Consultation Response from KC, Trees
2023/93737 Mirfield Air Cadet Centre, Huddersfield Road, Mirfield, WF14 9DQ
Erection of single storey modular building and band store with associated external alterations following demolition of two existing single storey modular buildings
Date Responded: 17/06/2024 Responding Officer: Jack Dunn Responding Ref:

client	Integra Buildings Ltd	created	28nov23
project	CRFCA Mirfield	job N°	230711
title	layout : proposed	scale	1:100 @ A2

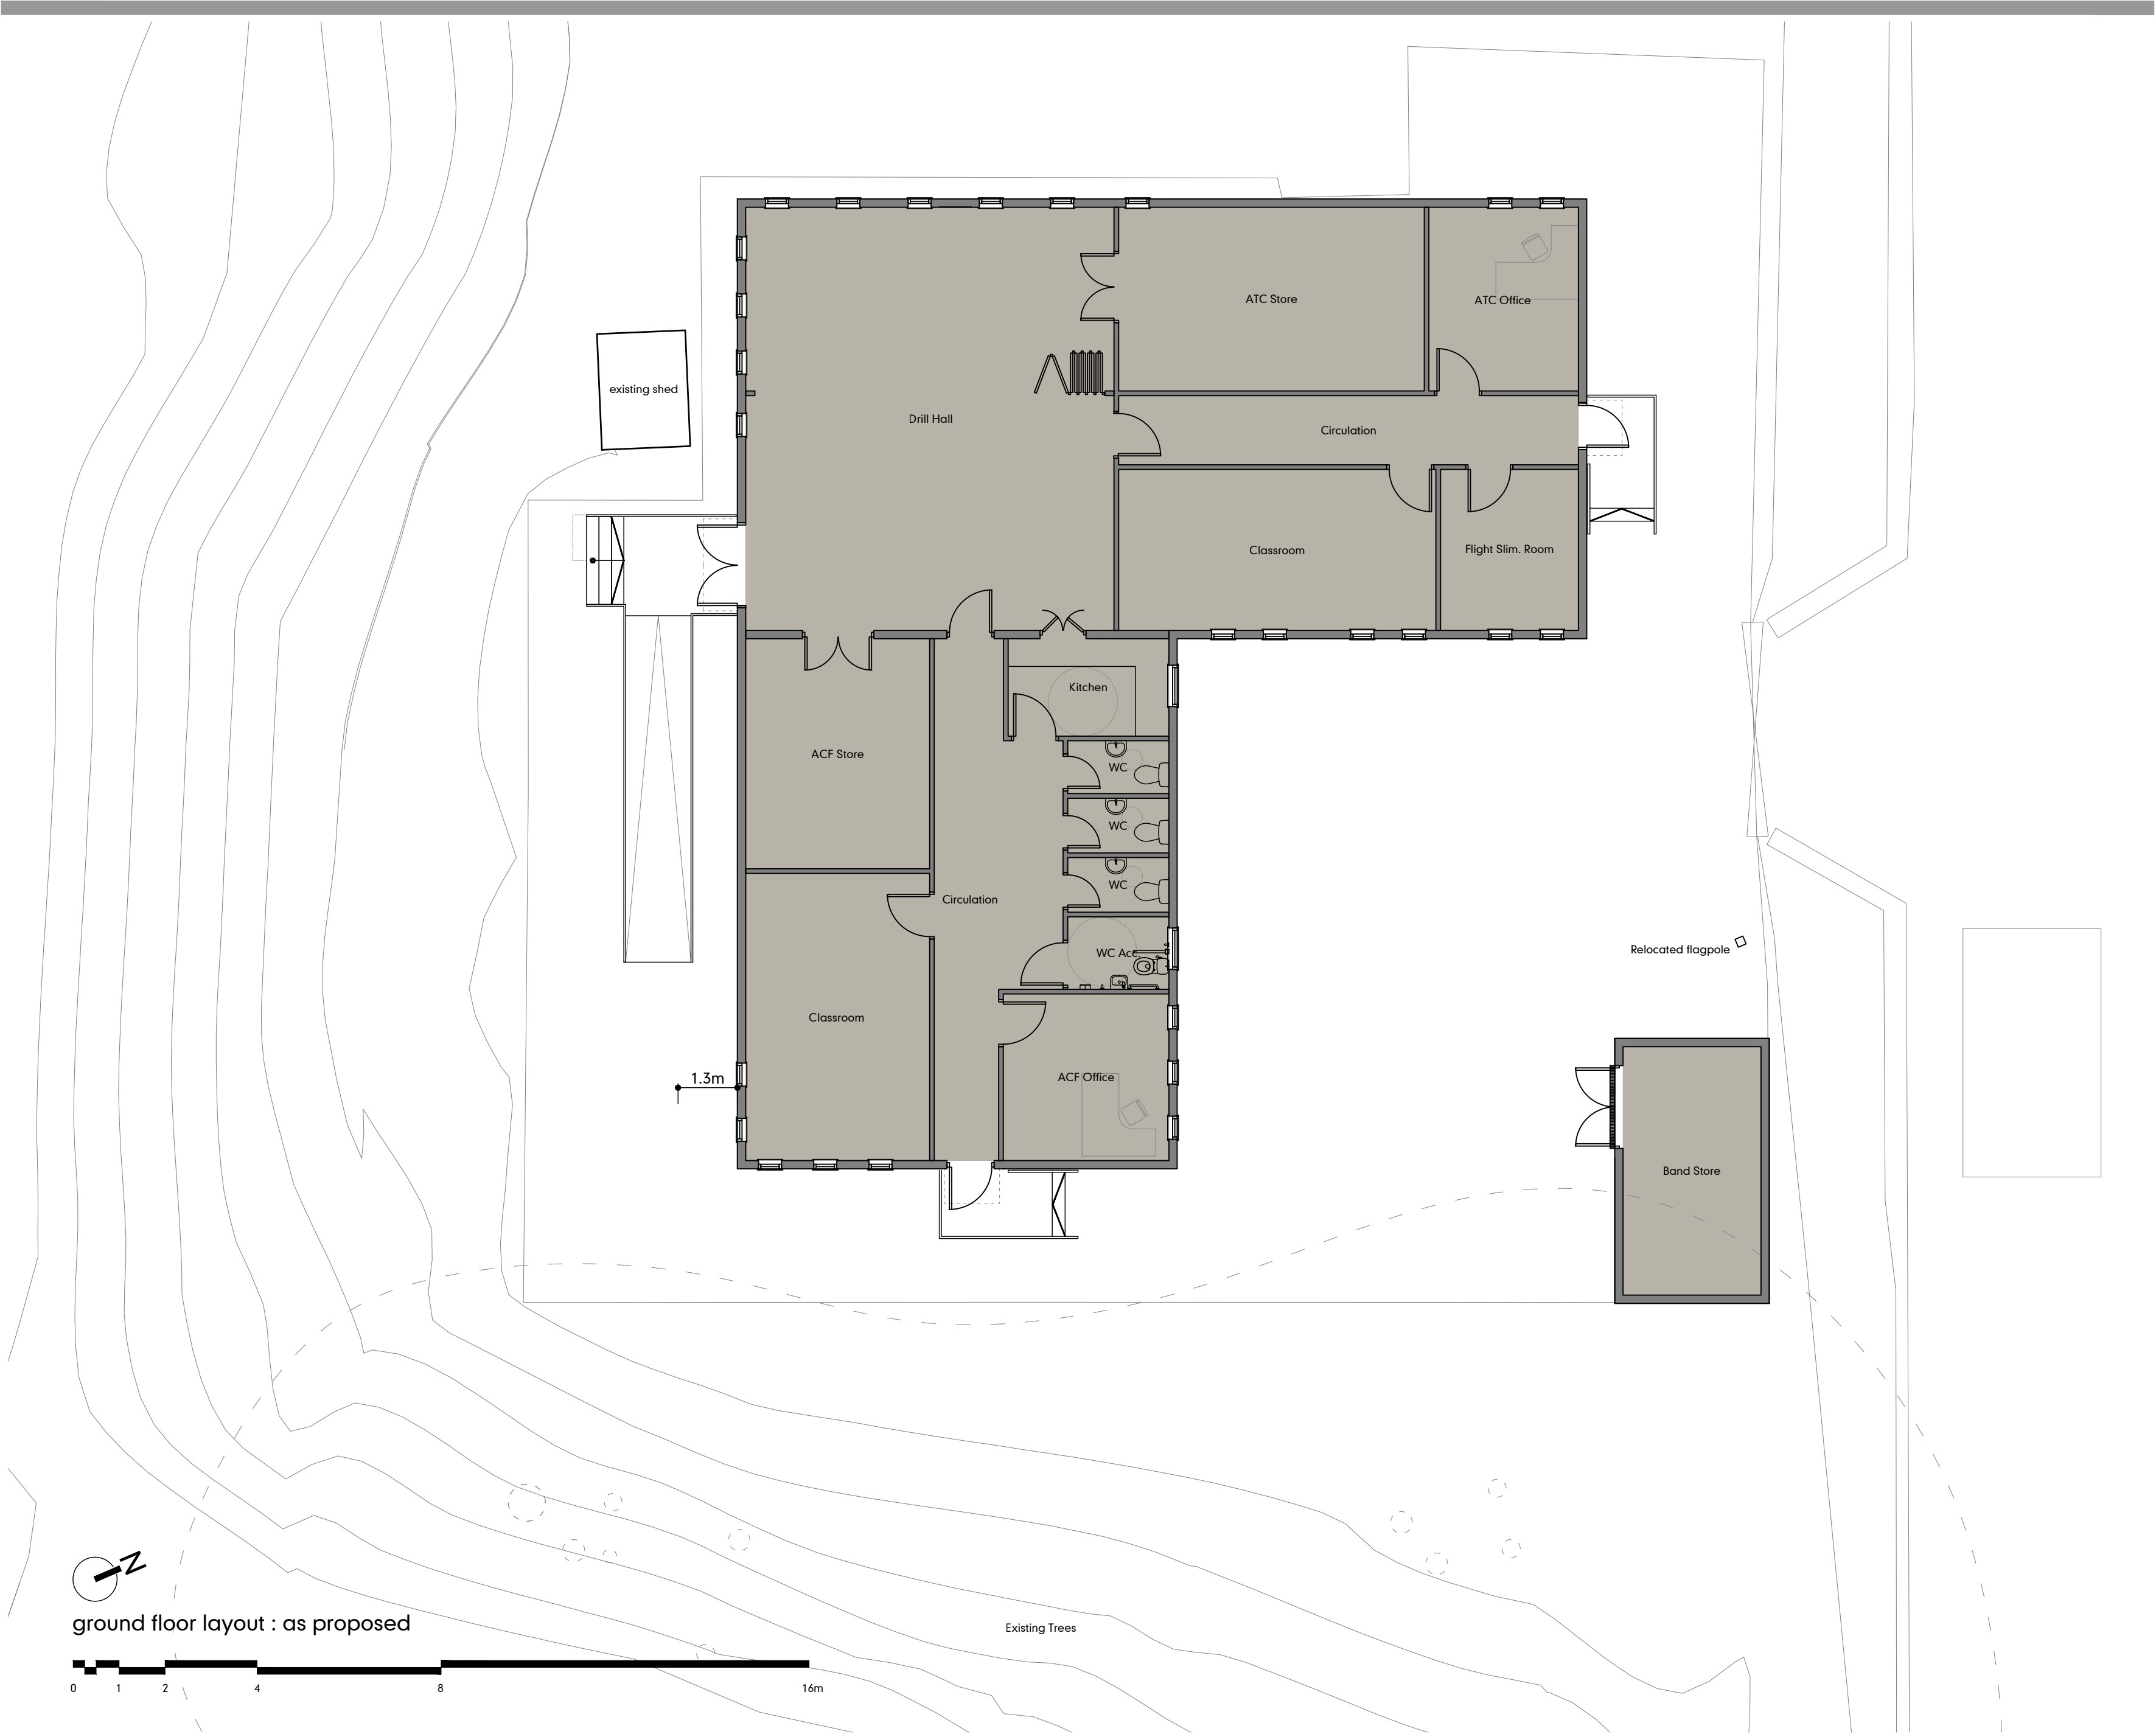
The site is heavily constrained by trees, however there are no protected trees on site. There is conflicting information/plans within the application. The proposed site layout drawing named 230711-015.04 by Williams architects is suggesting the only tree down for removal is T12. Whereas the information in the AIA provided by Arb Tech 230711-015.03 suggests G02, G03, T04, T05 and T12 are all for removal?

The Williams architects proposal 30711-015.04 is the preferred plan as this requires less tree removal to facilitate the development. All other information in the Arbtech Tree Protection Plan is sufficient including the new planning scheme.

The proposed replacement planting shown on some of the proposed plans isn't proportionate to the tree loss proposed. Notwithstanding that a suitable replacement planting could be achieved within the site, the replacement trees would take a considerable amount of time to reach the stature of that which currently exists, and the species proposed at the moment wouldn't be capable of matching the stature of what is there. Overall, there is a holding objection from a tree's perspective. Because the proposal is considered to be conflicting with adopted Kirklees Council Local Plan LP33 and LP24 (i).
